From: queencamel_clerk
To: [A303 Sparkford to Ilchester](#)
Subject: Written Representation from Queen Camel Parish Council
Date: 22 January 2019 18:12:11
Attachments: [Queen Camel Parish Council Written Representation.docx](#)

Please see attached the Queen Camel Parish Council Written Representation in respect of the A303 Sparkford to Ilchester Dualling Scheme DCO application. I would be grateful if you would acknowledge receipt of this email and attachment.

The Council has indicated its support for the proposed development at every stage of the consultation process but we have major concerns about three elements in the proposals, viz.

1. the absence of a detailed Traffic Management Plan for the construction phase;
2. the design of the Hazlegrove junction;
3. the absence of a local road parallel to the new dual carriageway.

**ENGINEERING SECTIONS
SLIP ROADS**

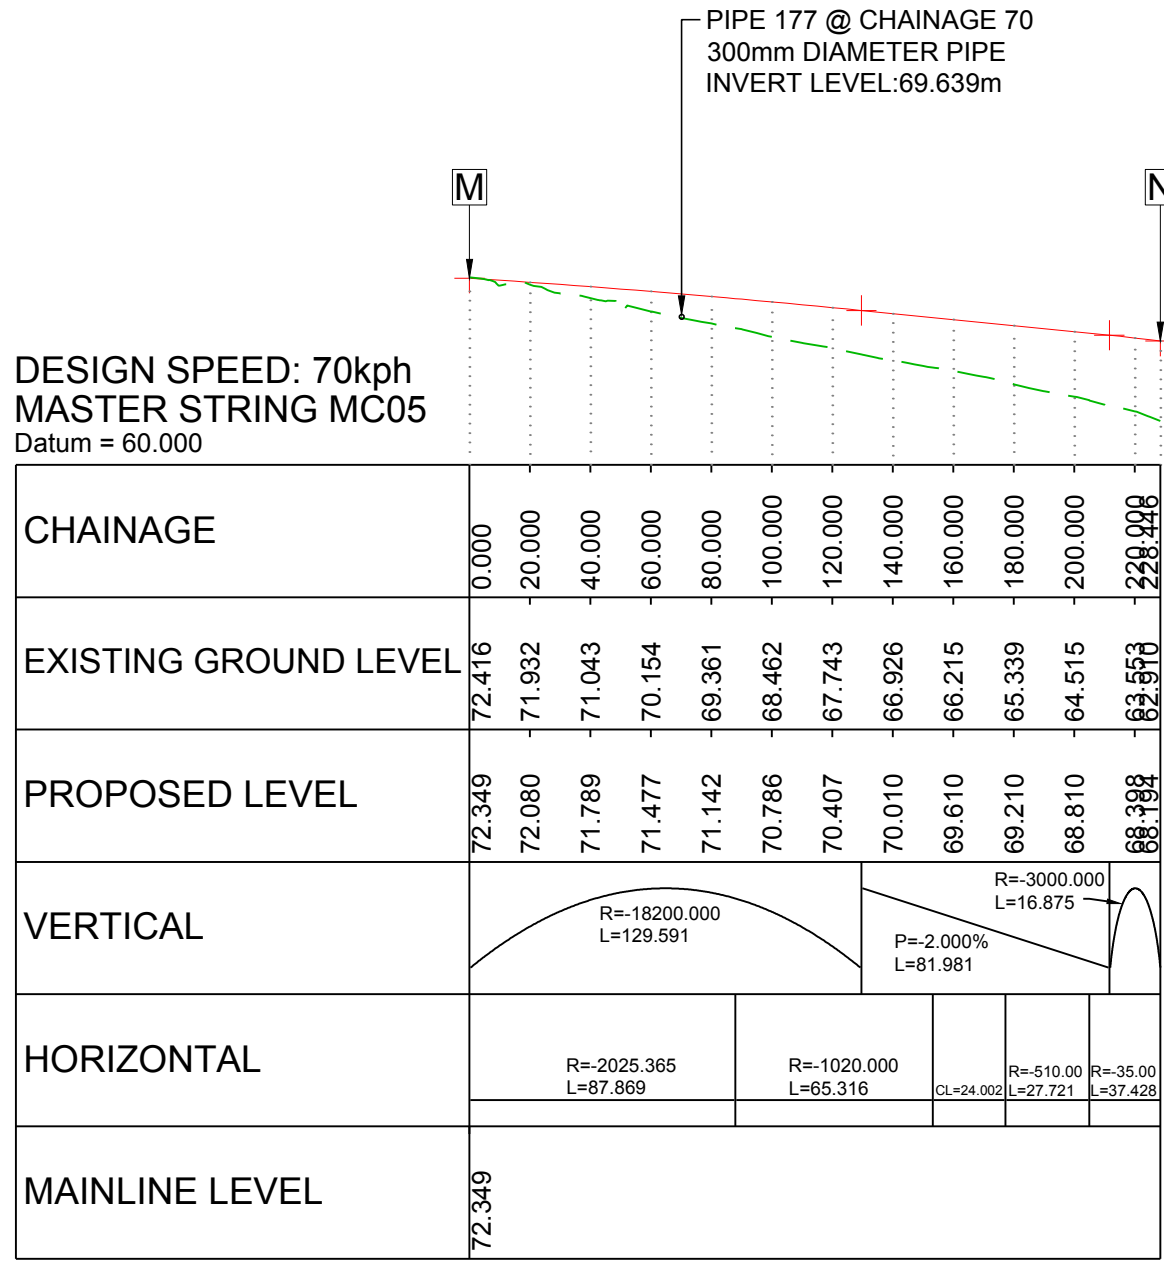
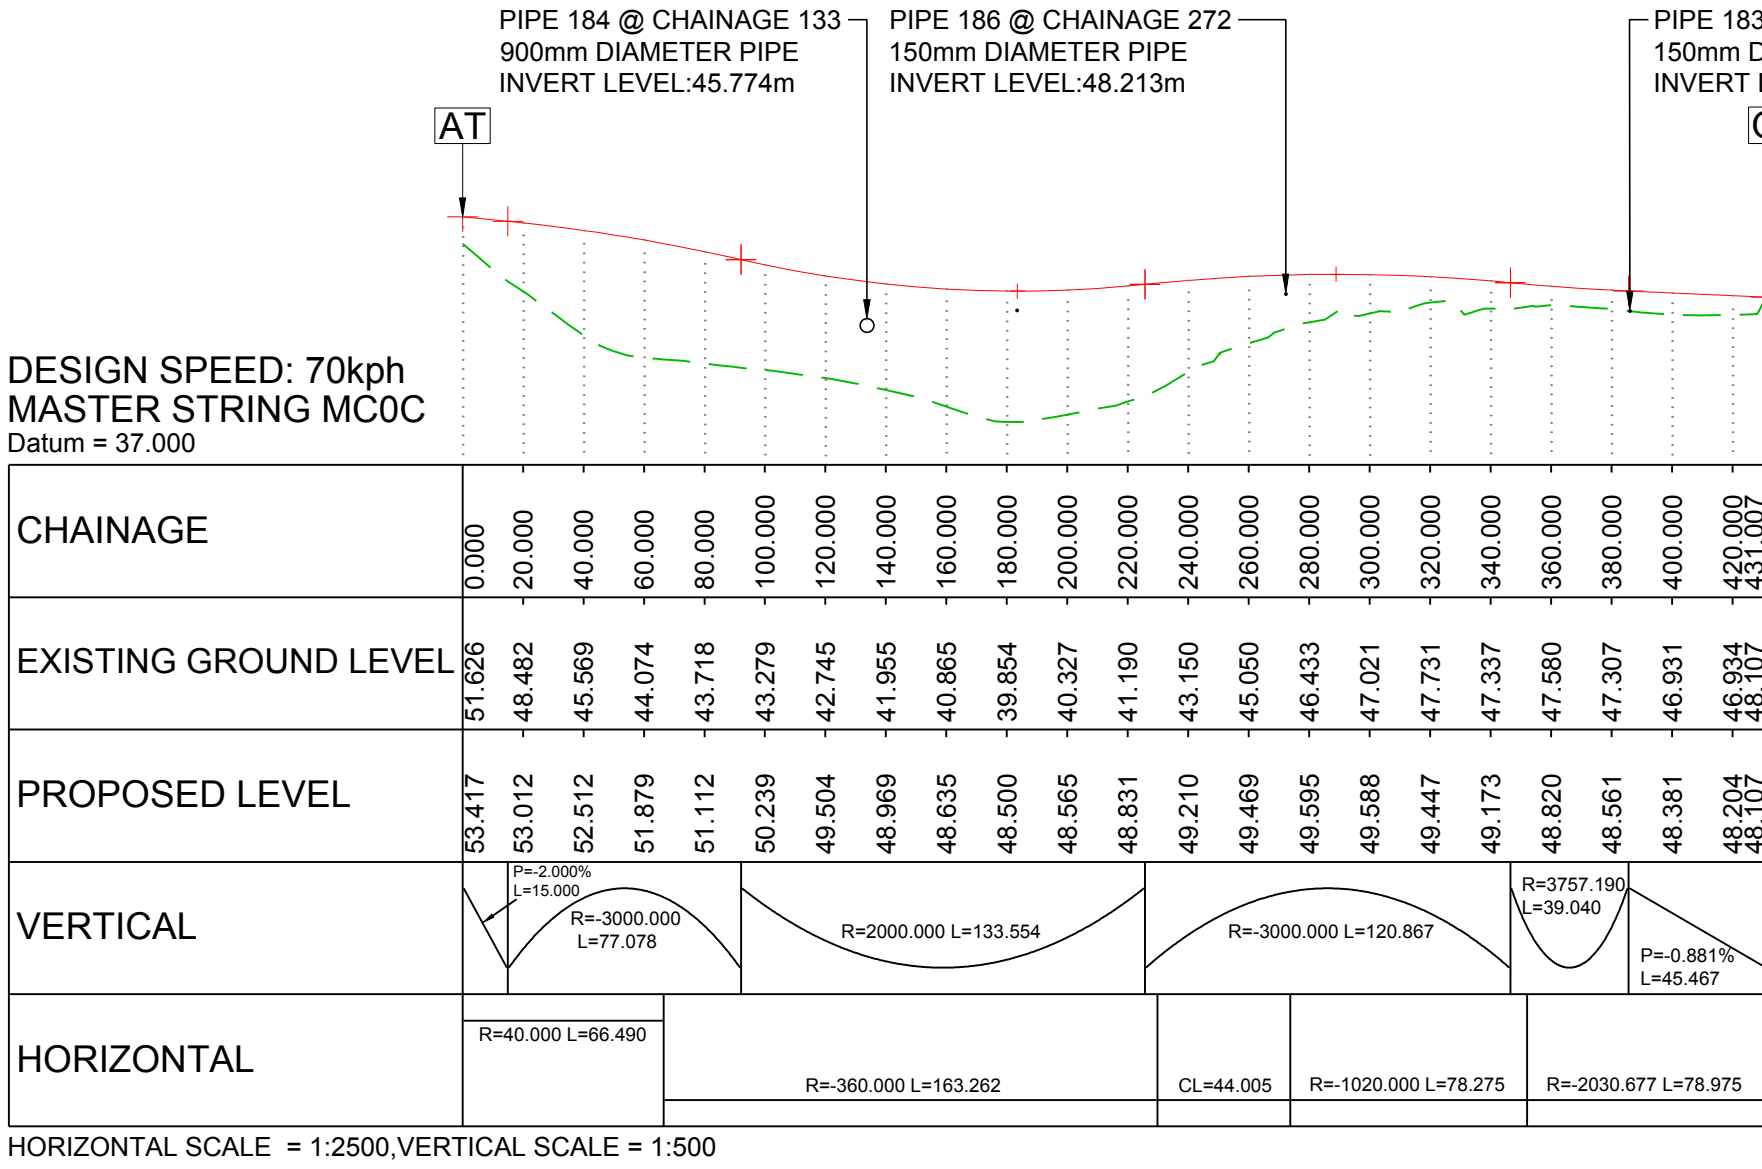
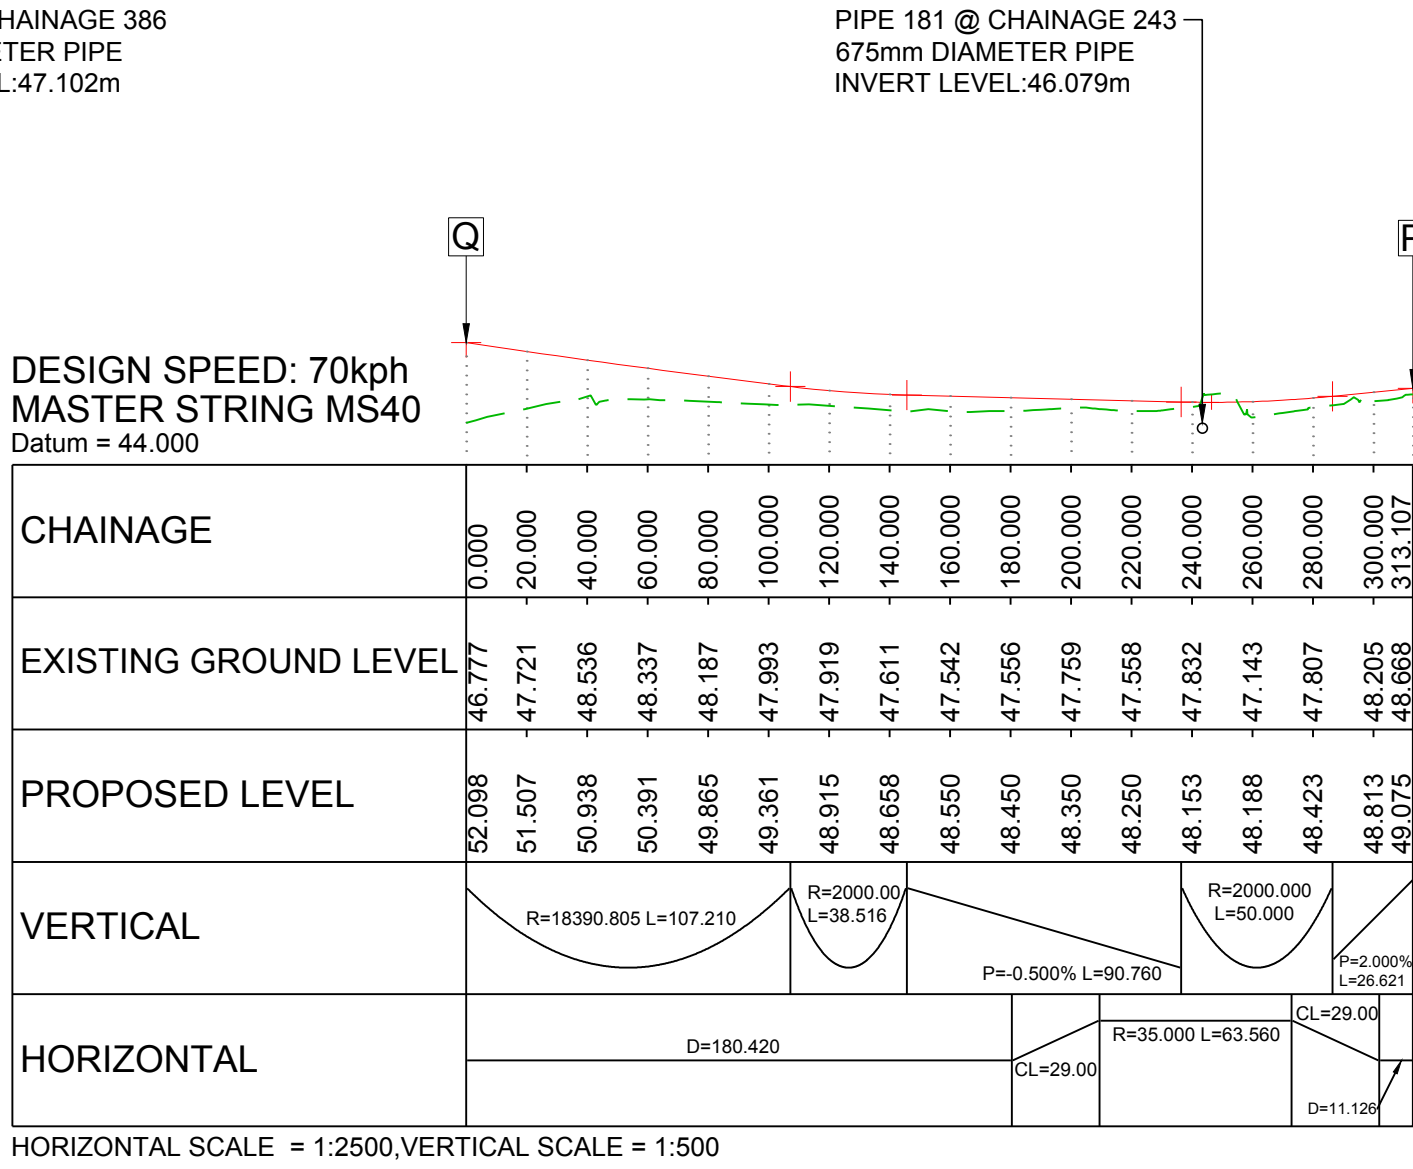
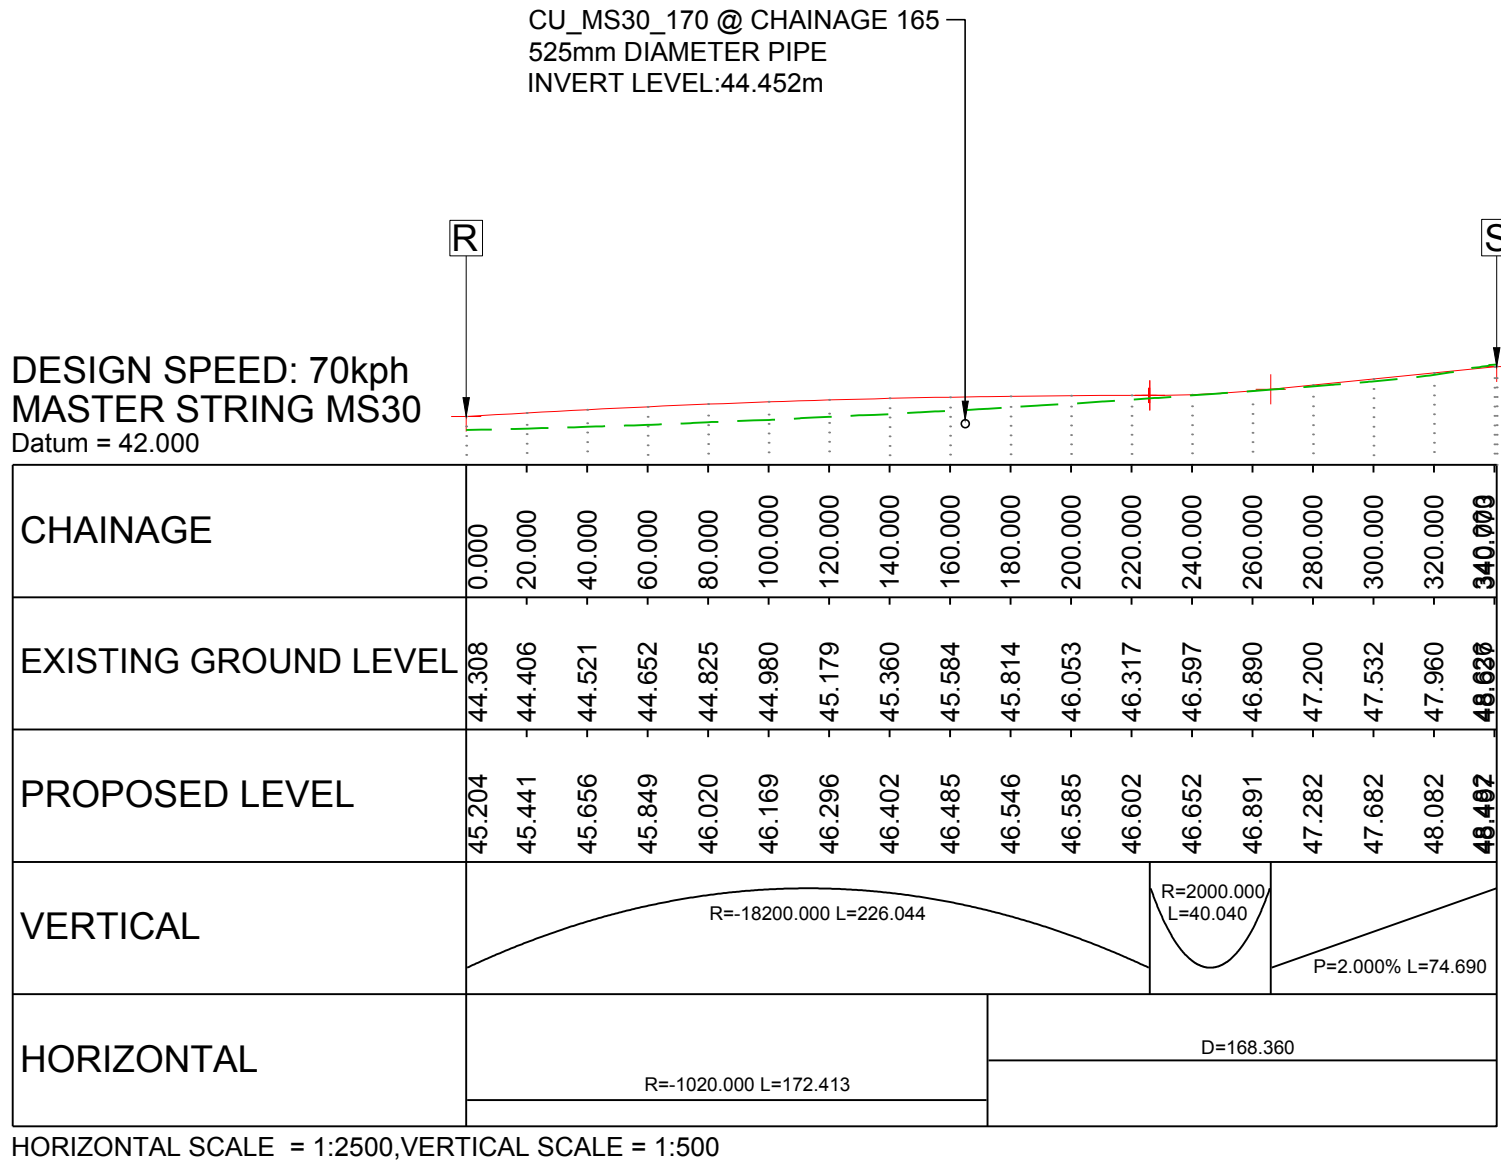
2. Hazlegrove Junction. The unorthodox design and layout of the proposed Hazlegrove junction will have a negative environmental and economic impact on local communities by:

- 1) destroying far more of the Listed Hazlegrove Park than is necessary;
- 2) needlessly increasing the length of journeys to and from Hazlegrove School and potentially causing gridlock at the beginning and end of the school day.
- 3) needlessly increasing the distance travelled by traffic joining the eastbound carriageway of the A303 from the A359 (south).
- 4) encouraging such traffic to take a short cut through the middle of Sparkford village.

The Council therefore asks the Examining Authority not to approve the DCO application without first considering the alternative design submitted by Mr Norman. It is demonstrably more sustainable, both environmentally and economically, and it would be cheaper to construct.
